Ribble Valley Borough Council
Council Offices
Church Walk,
Clitheroe
Lancashire
BB7 2RA

Phone: 0300 123 6780
Email: Kathryn.Walsh@lancashire.gov.uk
Your ref: 3/2024/0802
Our ref: 3/2024/0802/HDC/KW
Date: 07 November 2024

Location: Central Garage Warwick Street Longridge PR3 3EB
Proposal: Proposed industrial unit 59.5m sq behind existing industrial unit of 169m sq.
Grid Ref: 360216 437487

Job No:	240901	Drawn By:	J.L.
Date:	Sep 2024	Checked By:	J.L.
Scale:	1 / 250 @ A3	Drawing No:	240901/01

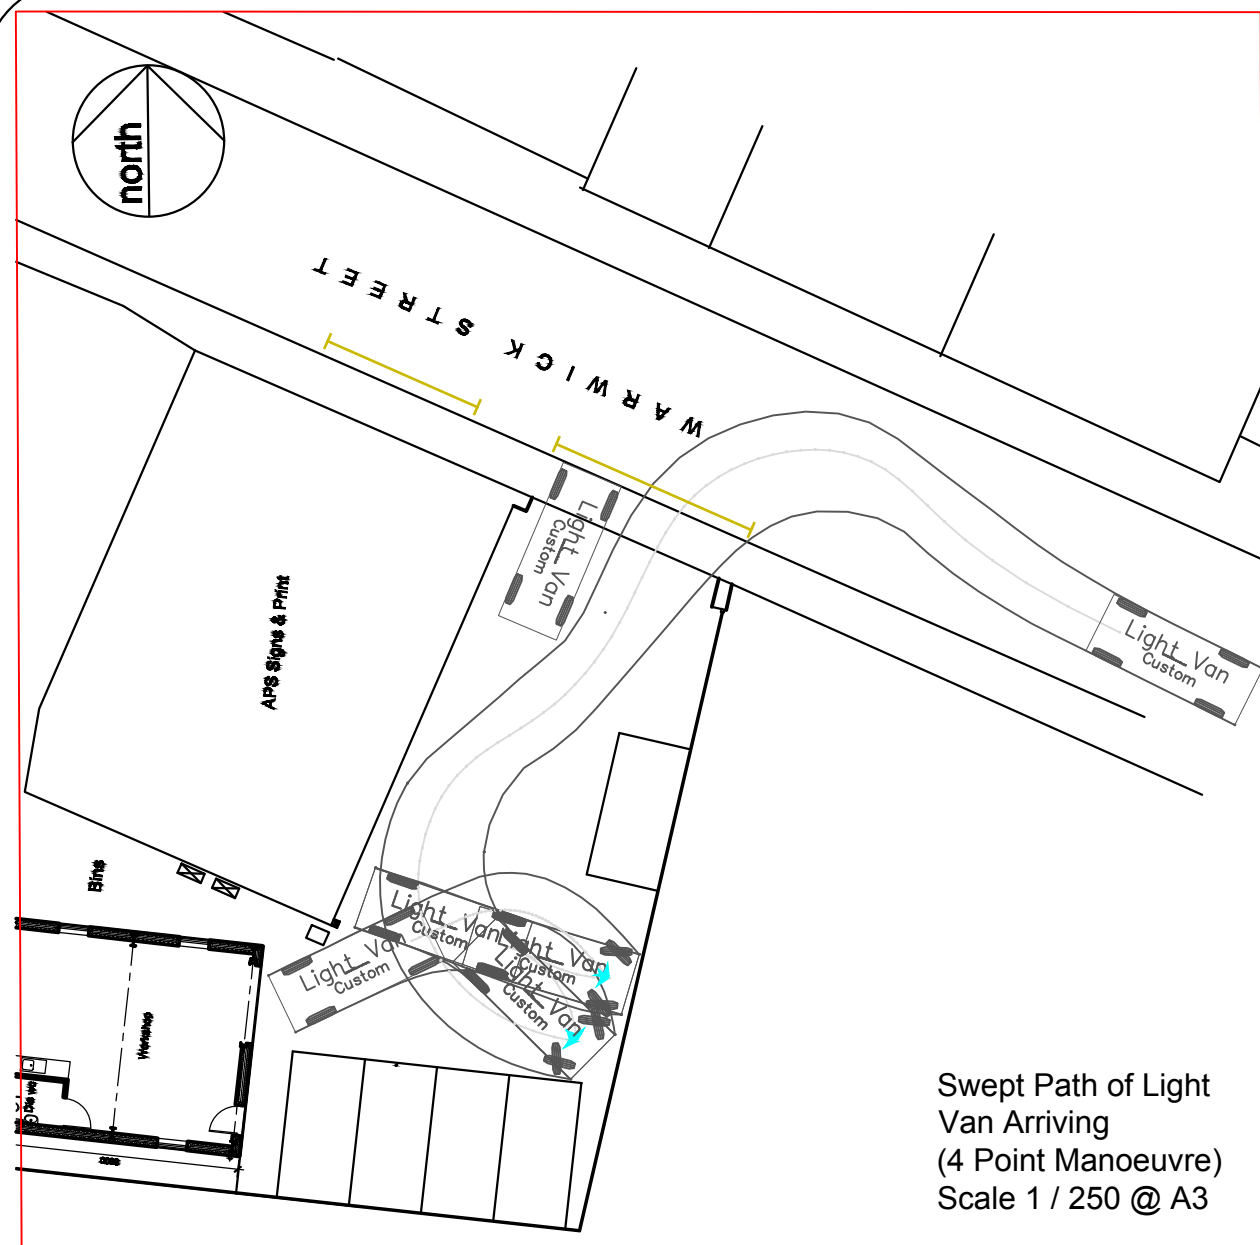
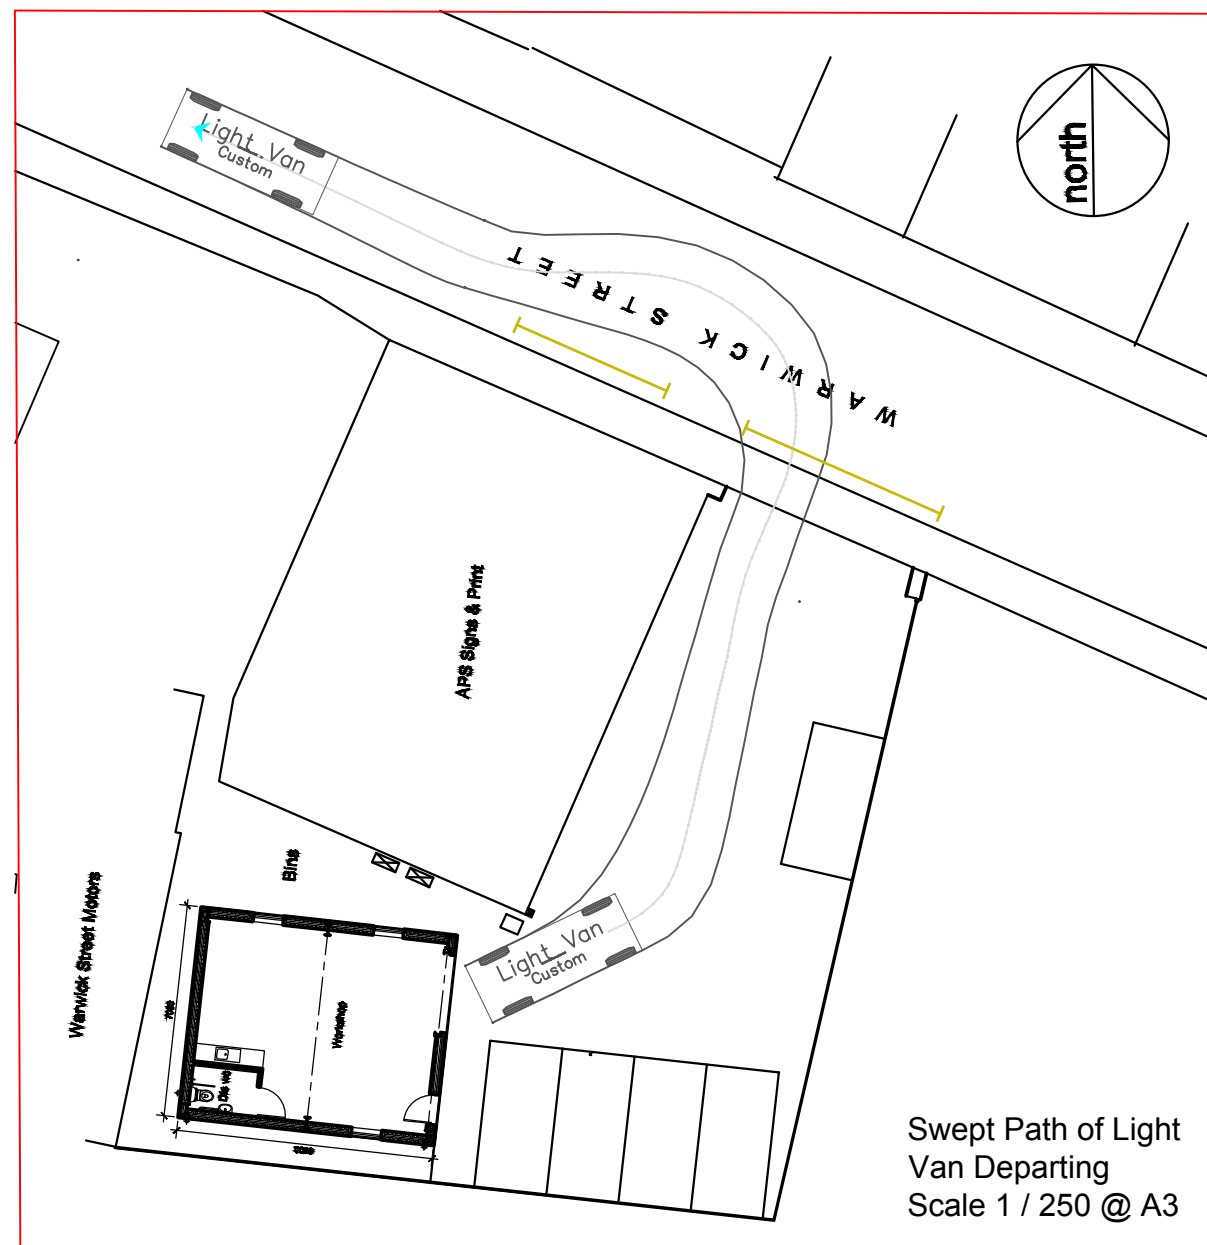
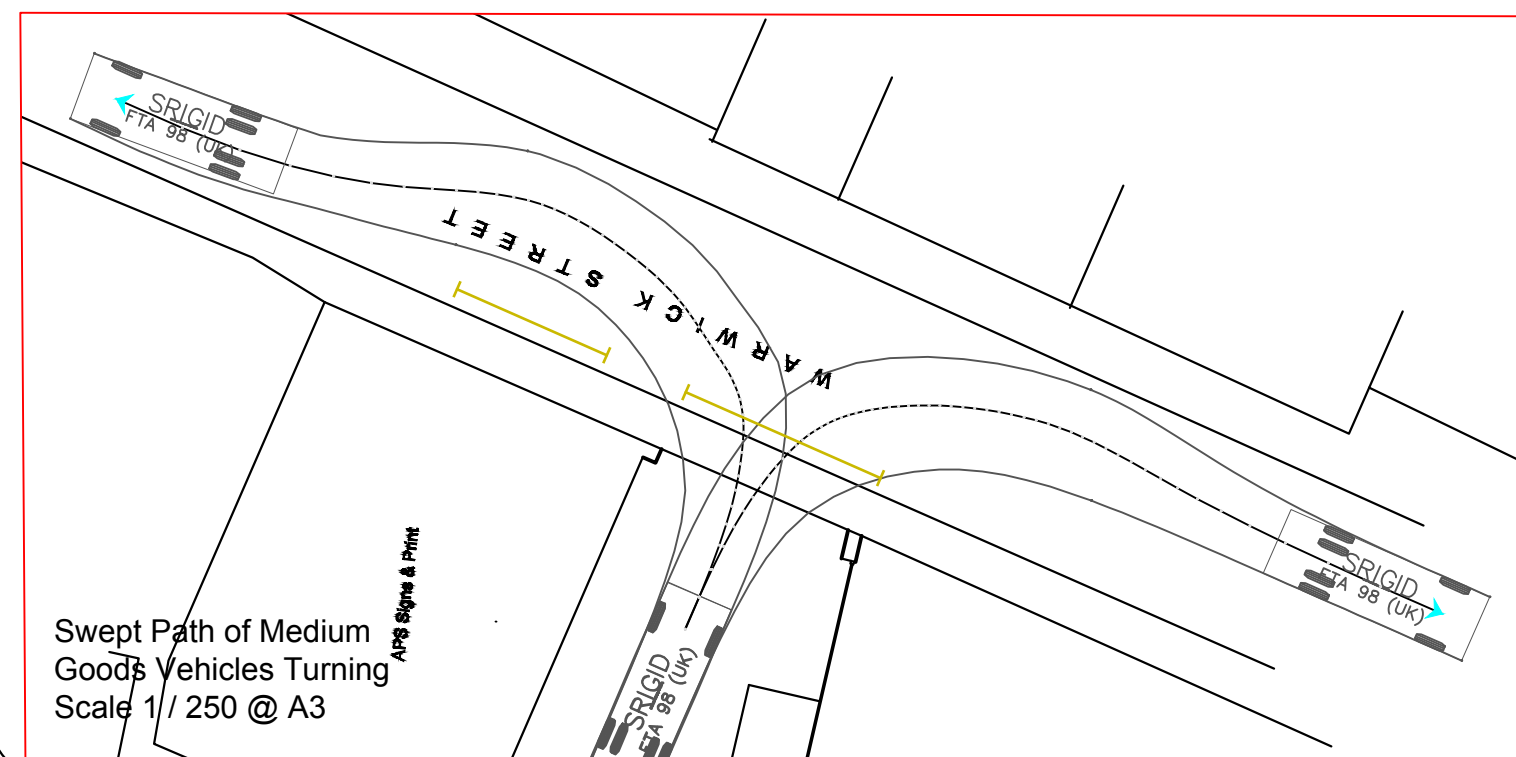
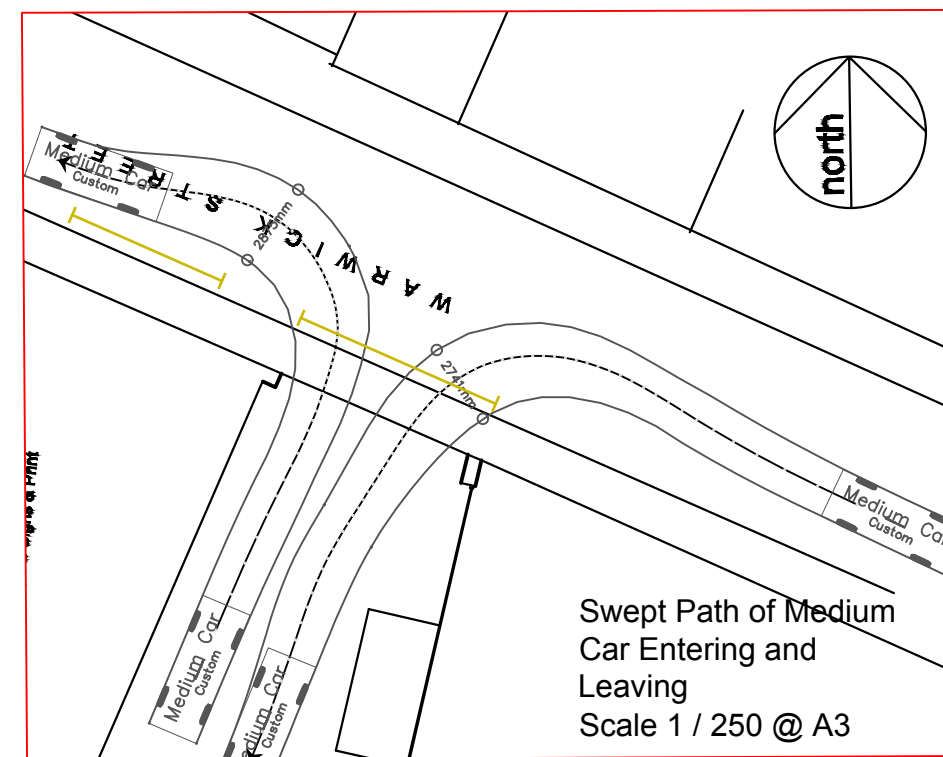
Whilst taking the internal floor area into consideration, the LHA only requires 1 car parking space to be provided for the proposed unit to comply with the LHAs parking guidance. The LHA has reviewed the amended drawing number 240901/01 and noted the site has a total of 5 off-street parking spaces, which is acceptable for the size and use class of both units.

The LHA are of the opinion that whilst drawing 240901/01 shows a lights goods vehicle accessing the site, turning within and exiting the site in a forward gear, the LHA do have concerns over the practicality of such vehicles turning in practice given the limited space available.

The applicant has stated that deliveries also take place in large vans therefore it is the LHAs opinion that this is represented in the Swept Path of Medium Goods Vehicles Turning shown within drawing 240901/01. The applicant has also provided further clarification on the manoeuvring of such vehicles in order to serve the site *'drawing 240901/01 shows a medium goods vehicle reversing into the site and exiting the site in a forward gear'*. Vehicle turning within the site for a medium goods vehicle is not possible, the drawing also does not represent the true street scene. To undertake such a manoeuvre would require that no vehicle parking takes place adjacent to the access and opposite. A site visit and Google Street View shows that this is not the case on Warwick Street. Whilst the applicant has very recently applied for a H Bar, a recent site visit and Google Street View history indicate that the H Bar markings already present on Warwick Street are not fully self-enforcing and overhang parking does take place. This also does not take into account parking on the opposite side of Warwick Street. As can be seen from drawing 240901/01 even with a H Bar marking, the vehicle turning would still cross over sections which cannot be protected.
